WEST SUSSEX COUNTY COUNCIL CONSULTATION

TO:	Arun District Council FAO: Leanne Richardson
FROM:	WSSC – Highway Authority
DATE:	19 September 2024
LOCATION:	Land at Woodgate Nurseries Lidsey Road Woodgate
SUBJECT:	AL/89/24/OUT Outline planning with all matters reserved (except access) for the demolition of existing redundant nursery buildings and other structures and erection of a residential development of with up to 130 No dwellings, informal and formal public open space, landscaping, drainage, and other associated works. This application may be a Departure from the Development Plan.
DATE OF SITE VISIT:	12 September 2024
RECOMMENDATION:	More Information Required

Pedestrian/Cycle Access (HTp/2401/04/C)

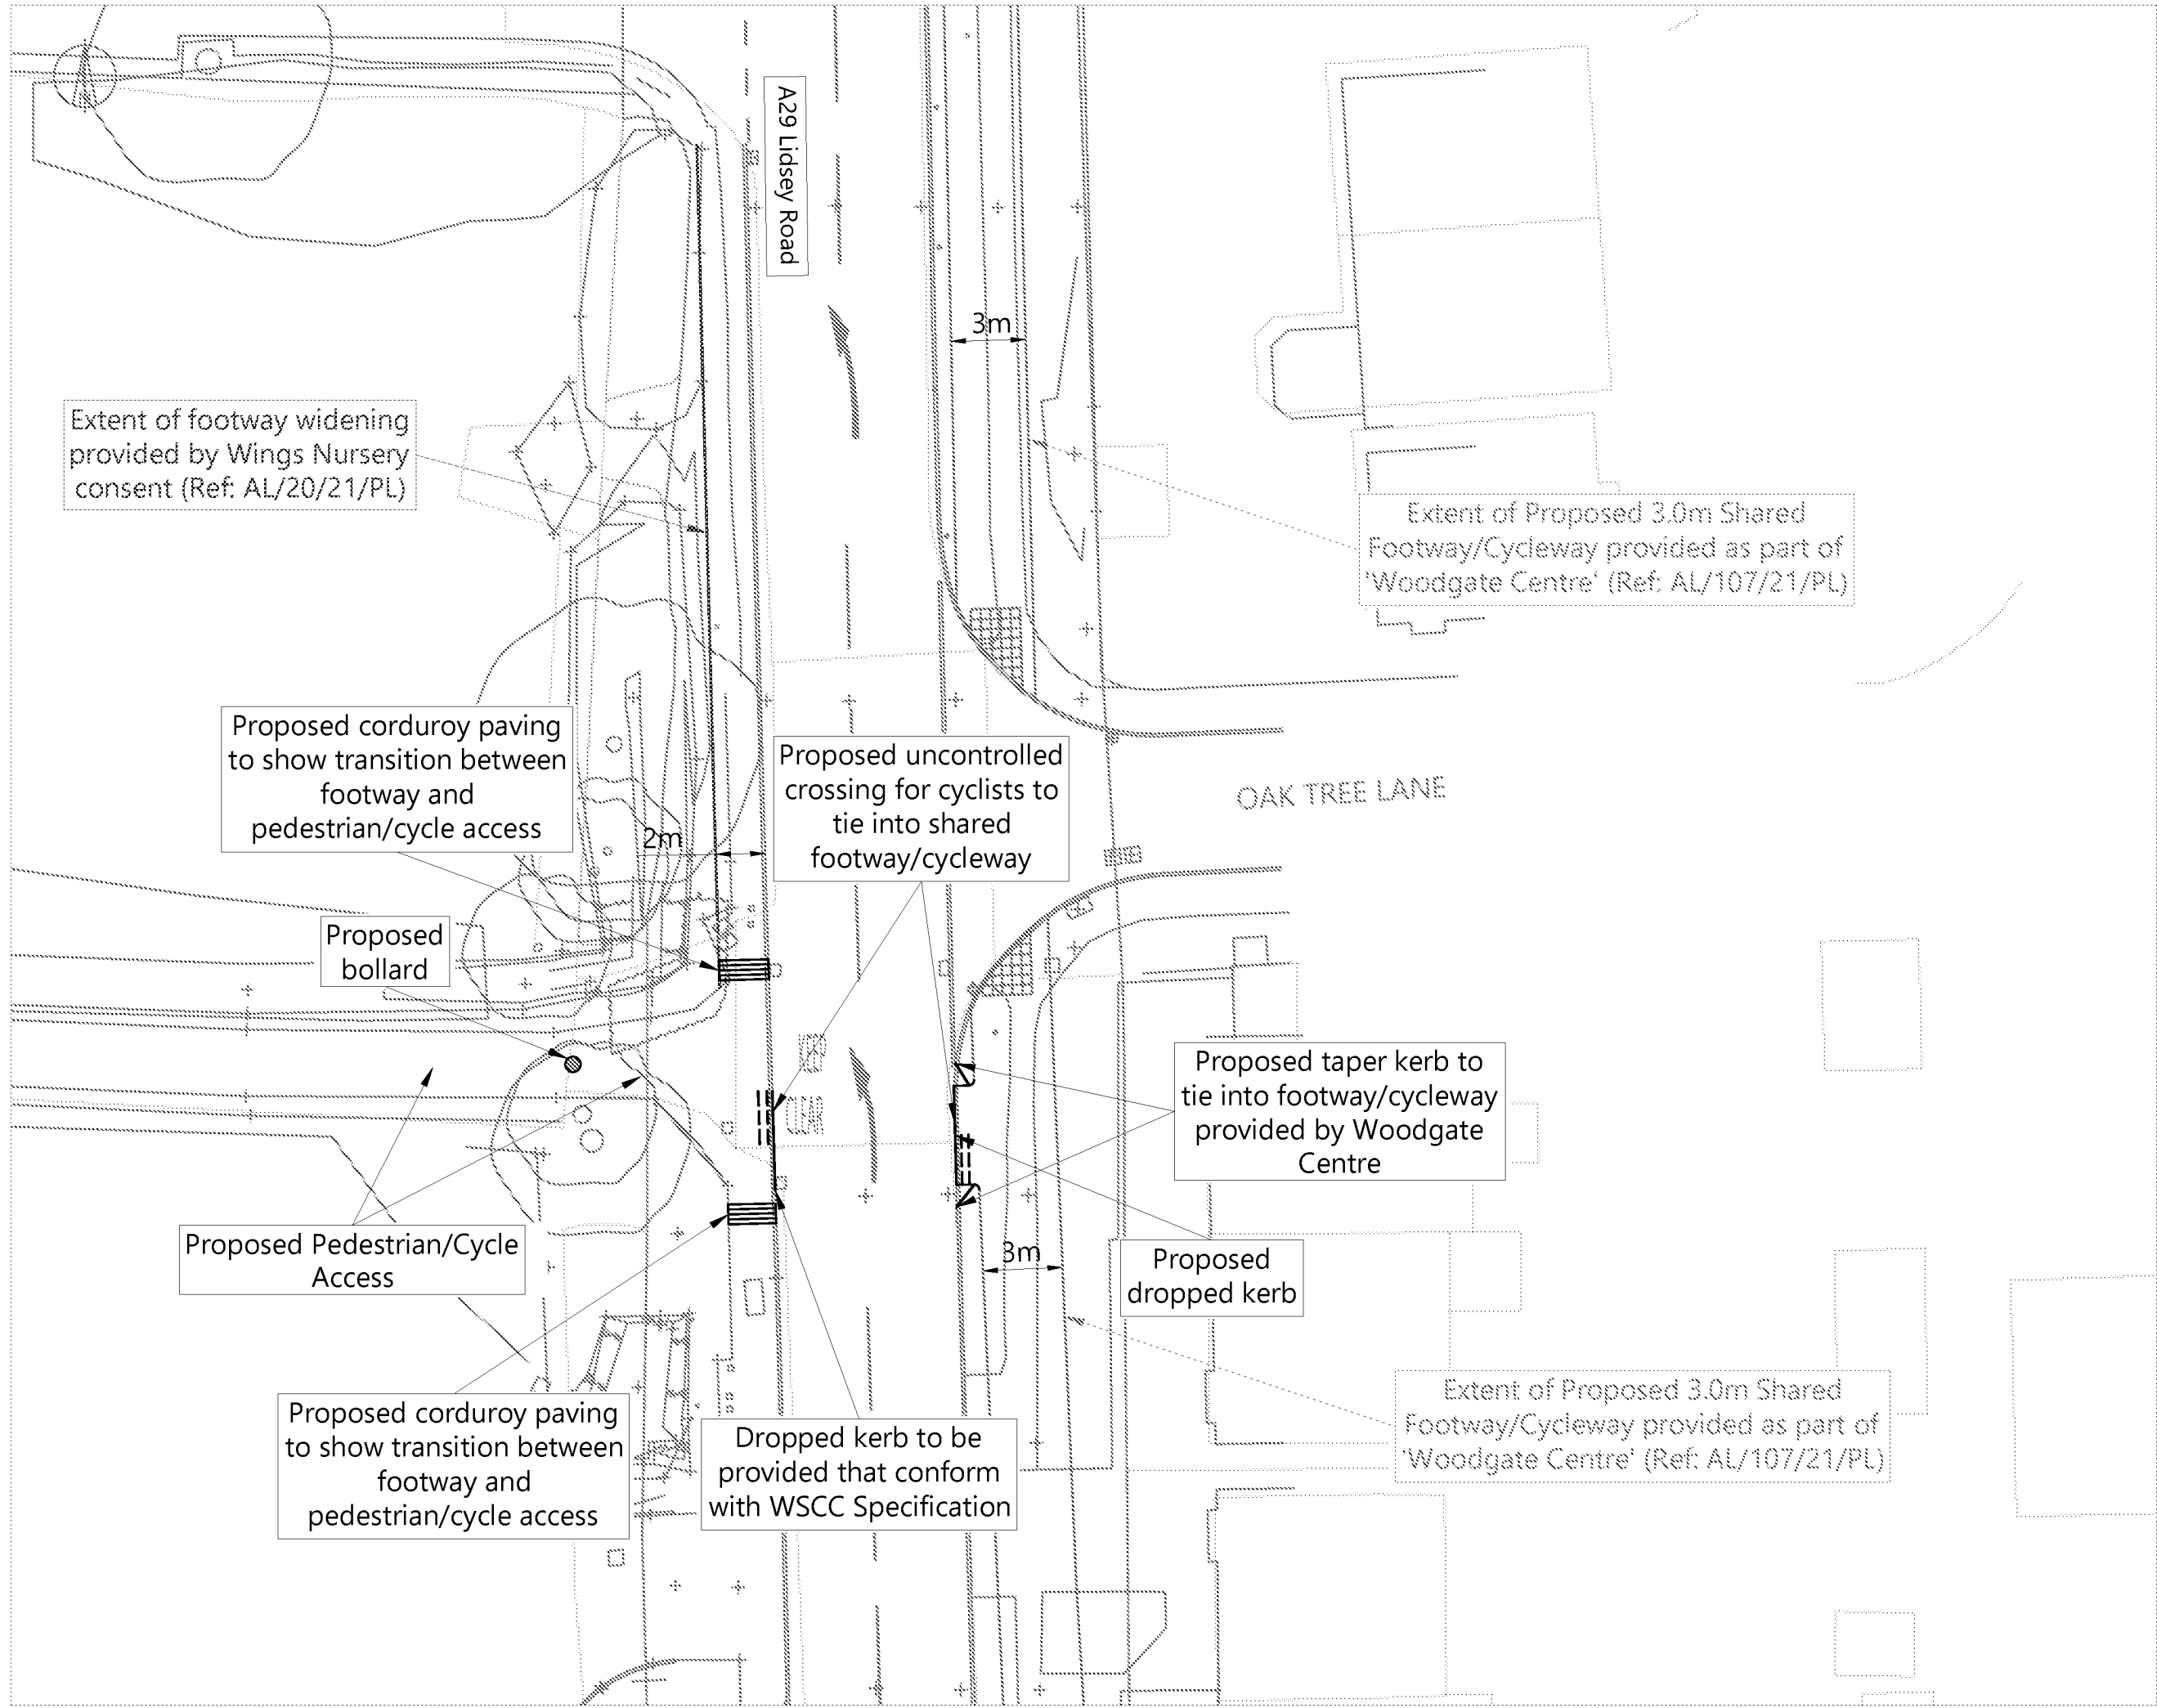
The proposed development, the subject of this current planning application, will result in the access road being closed to vehicular access, instead providing a connection from

the site for pedestrians and cyclists and emergency purposes. However, further detail of this, including its connection with the existing A29 and how such works interface with off-site foot and cycle highway improvements proposed as part of the nearby Woodgate Centre scheme, should be provided.
